Bulli Aged Care Centre of Excellence

BCA ASSESSMENT REPORT

REPORT 2016/0041 R1.1

25th July 2016

01 SECTION BB  
1:200

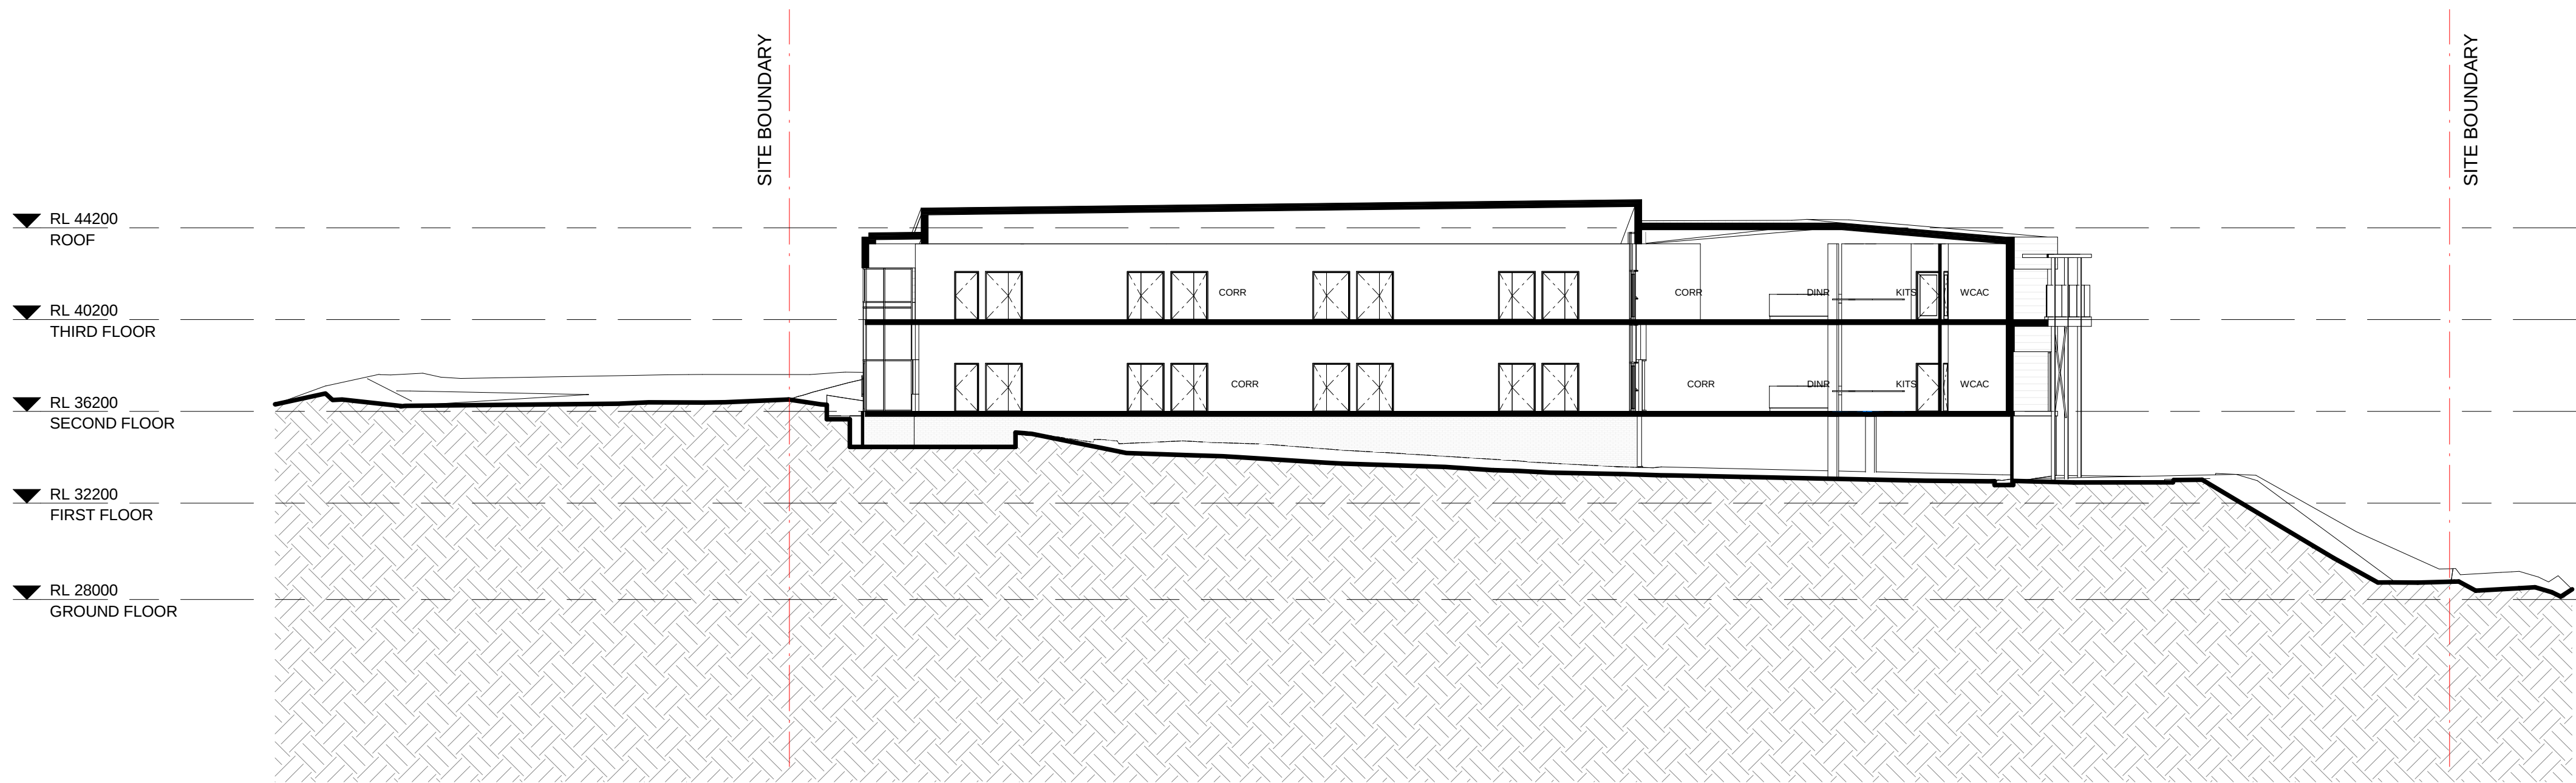
4.	Non-required stairs, ramps or escalators	D1.12	The lobby stairway connects four storeys.	CP2 & EP2.2
